Application for Planning Permission for Works or Extension to a Dwelling

Development: Rear extension with doors onto the garden; replacement of 1no. rear window and the regularisation of the existing annex space.
Location: Padraig Place 6 Ancton Way Elmer Middleton-On-Sea PO22 6JN

Proposed Rear Elevation

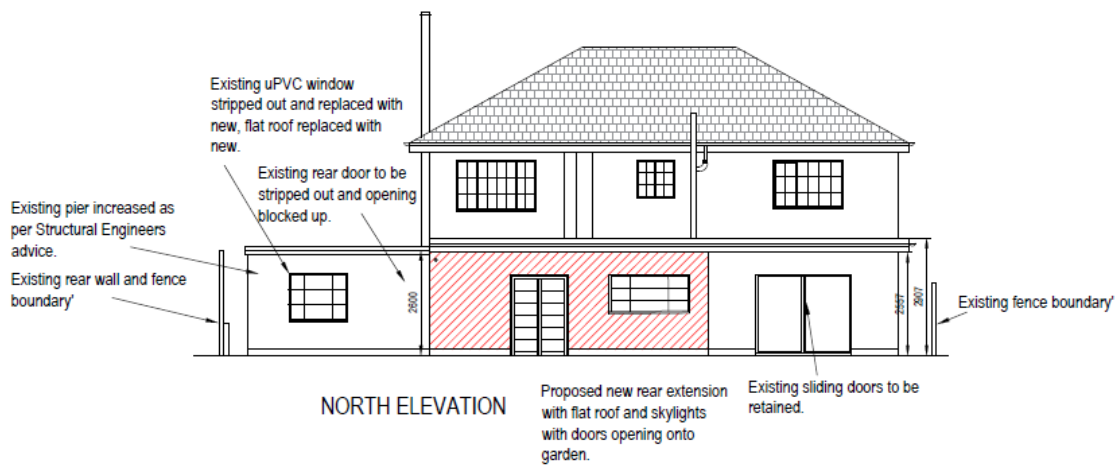
Drawing title - Proposed Elevations North and South (Drg No. SDF-ELEV-02 REV B) appears to be labelled incorrectly as the plans are labelled east and west. Please amend.
